CITY OF ALBUQUERQUE

October 14, 2016

Re: Townhouses for Worque, LLC
12844 Lomas
Traffic Circulation Layout
Engineer's/Architect's Stamp 10-05-2016 (K22-D057)

1 TRAFFIC CONTROL LAYOUT
Scale: 1" = 20'-0"

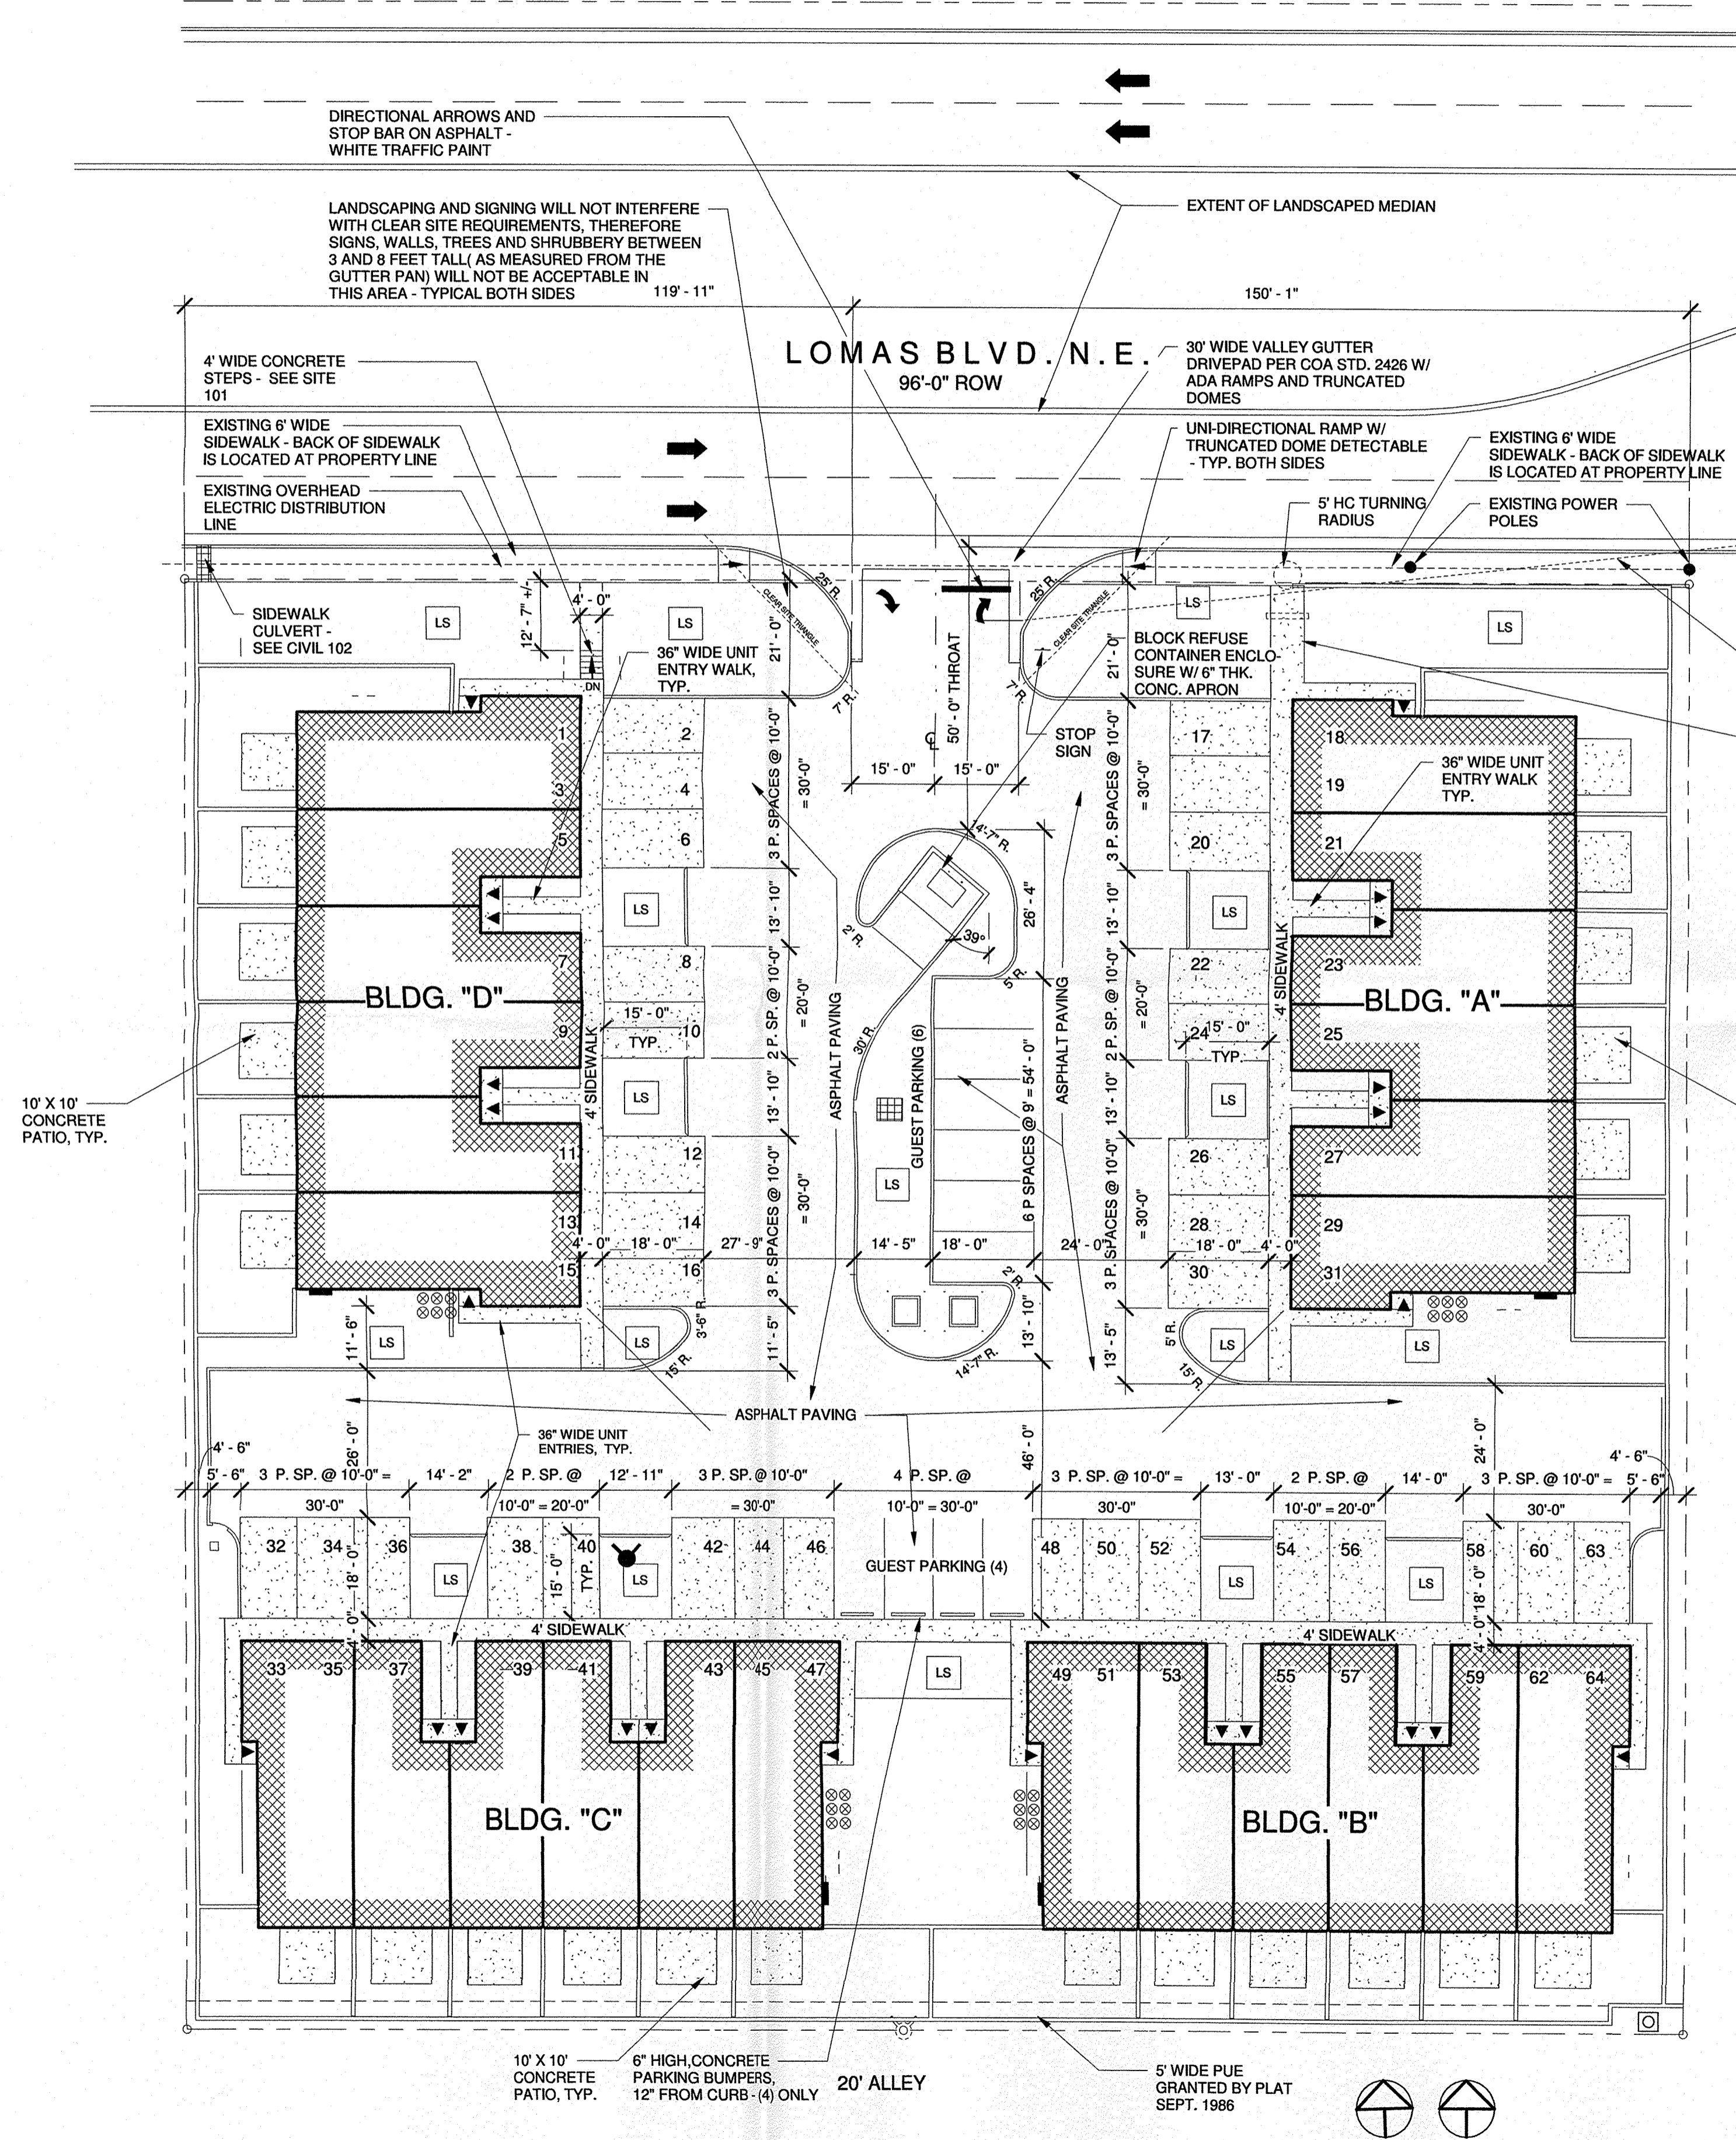
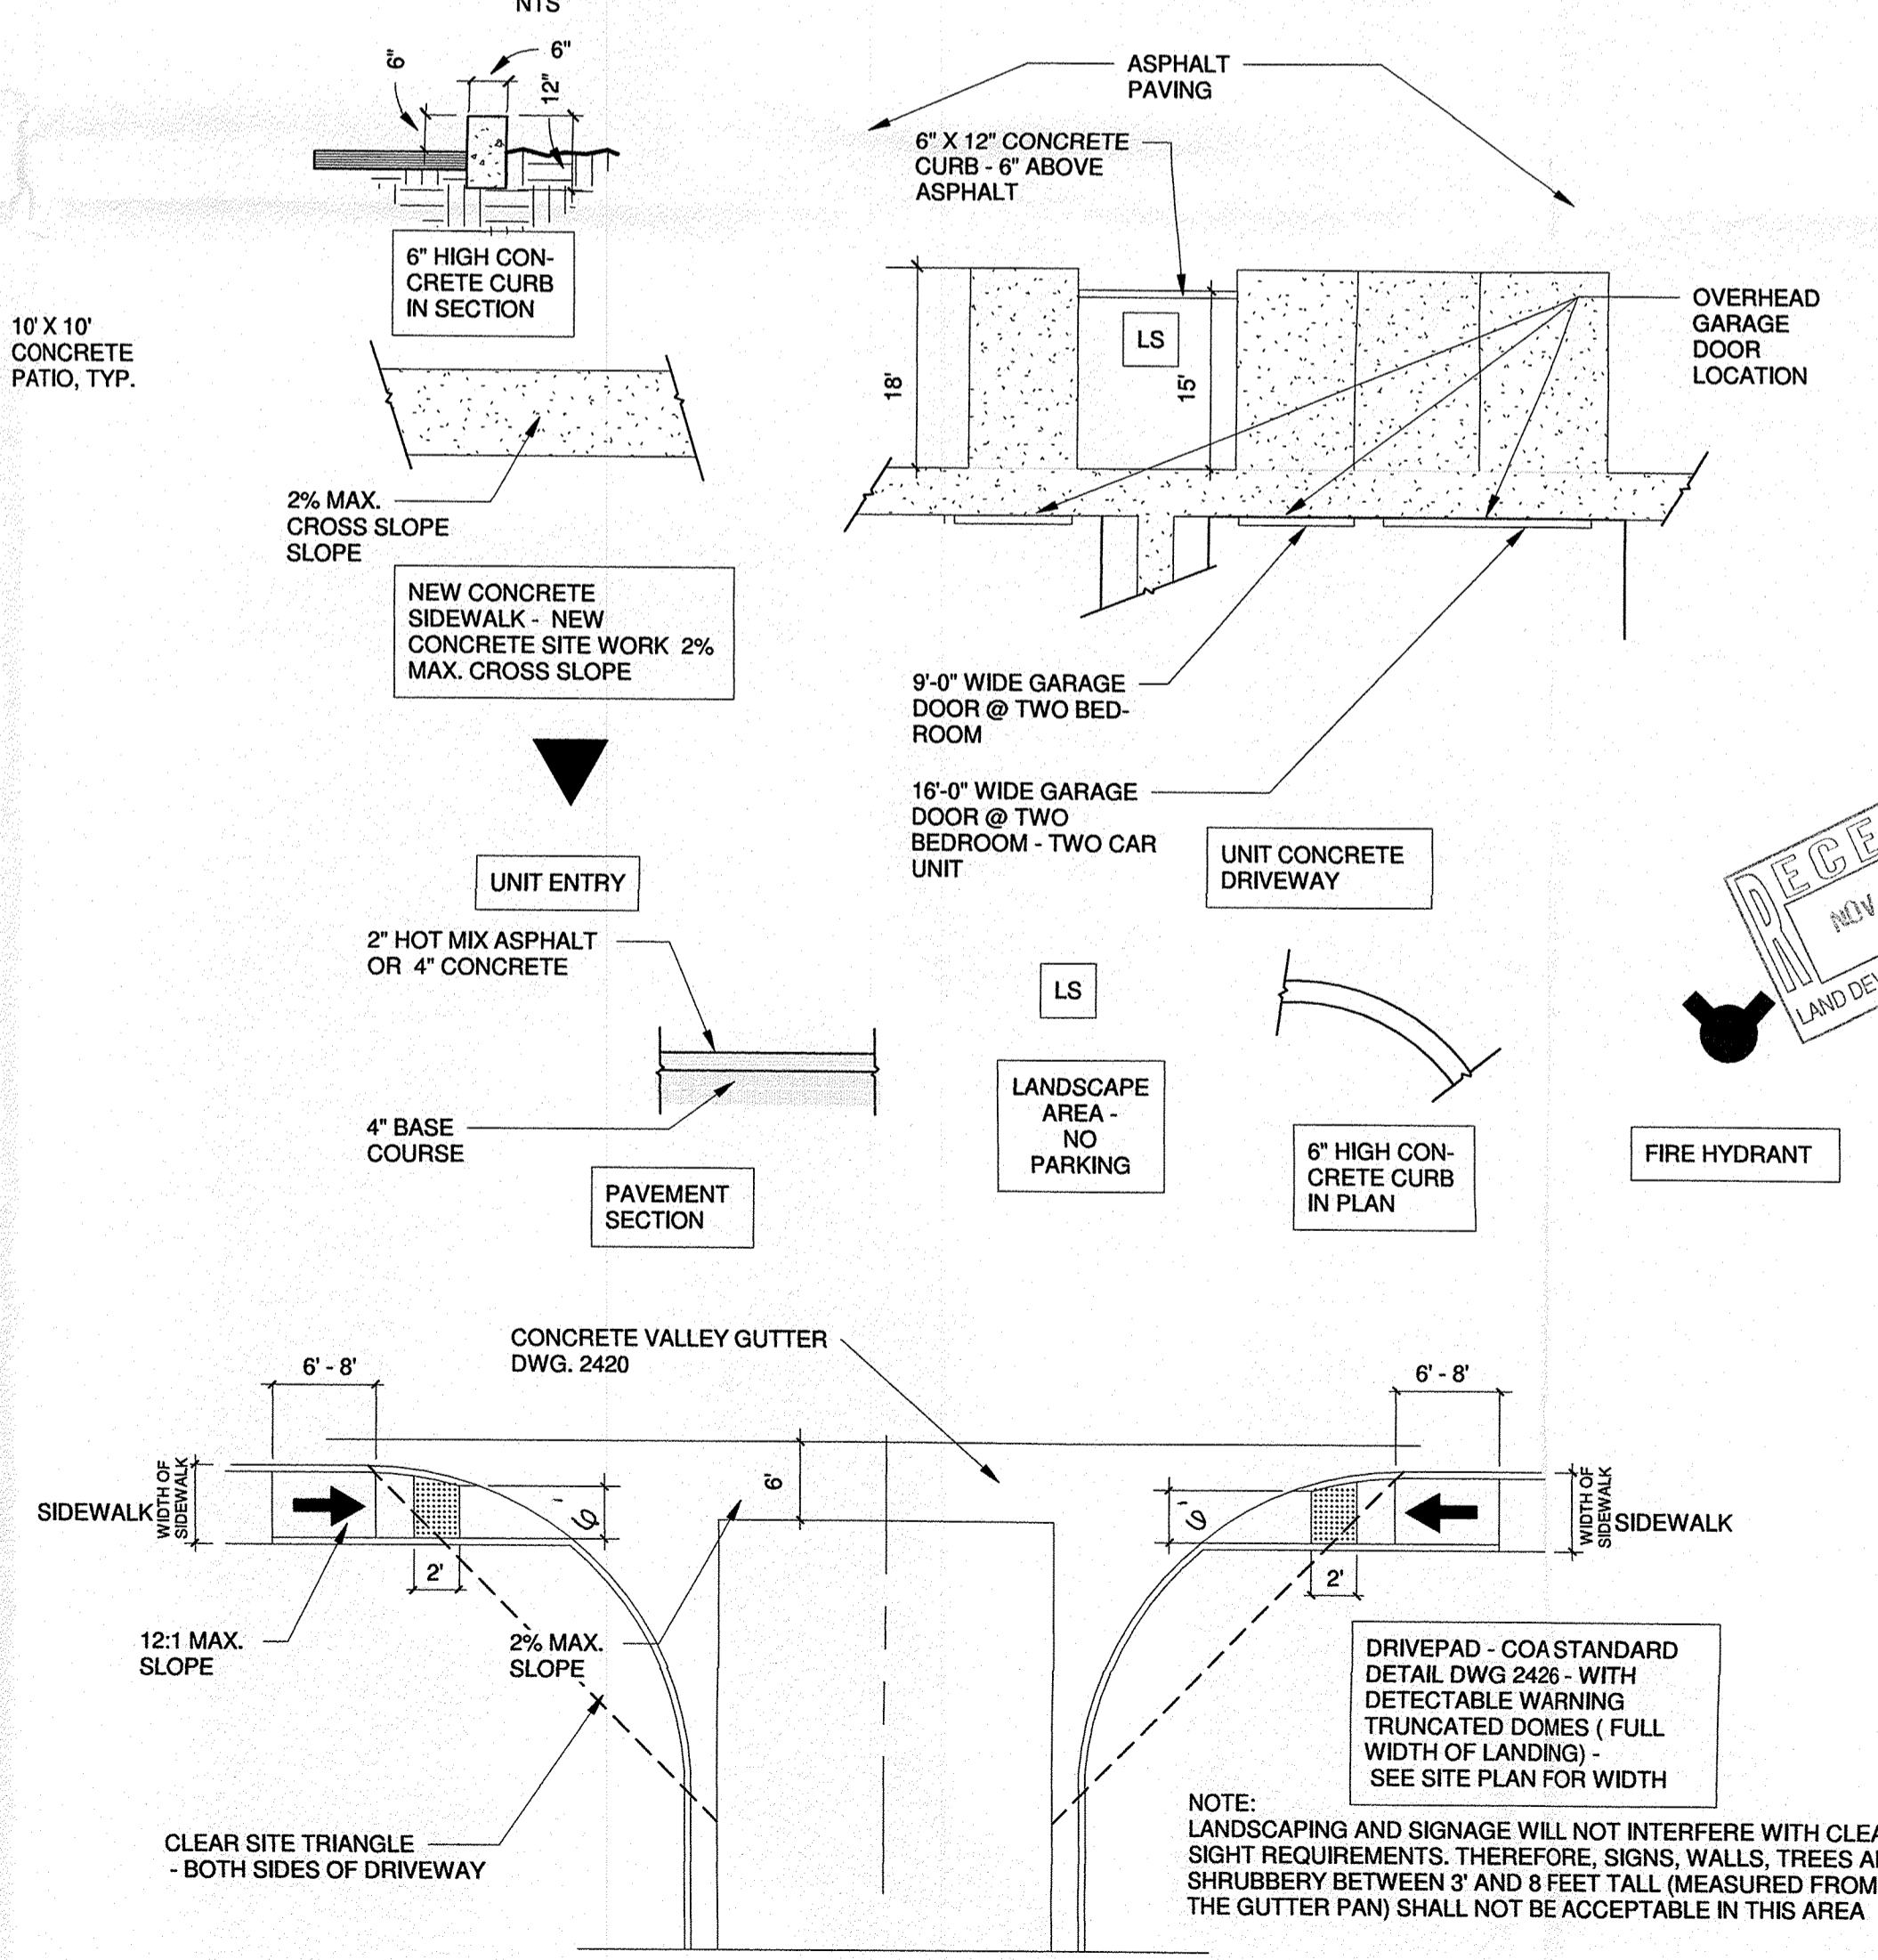
1. Please show dimensions on the stairs from the public ROW to BLDG. "D".
2. Per the zoning code, a 6 ft. wide ADA accessible pedestrian pathway is required from the public sidewalk to the building entrances. Please clearly show this pathway and provide details.
3. Provide a min 6" or max 8" high concrete barrier curb or other acceptable barrier between landscaping, parking areas and sidewalks. Please call out detail and location of barrier curb.
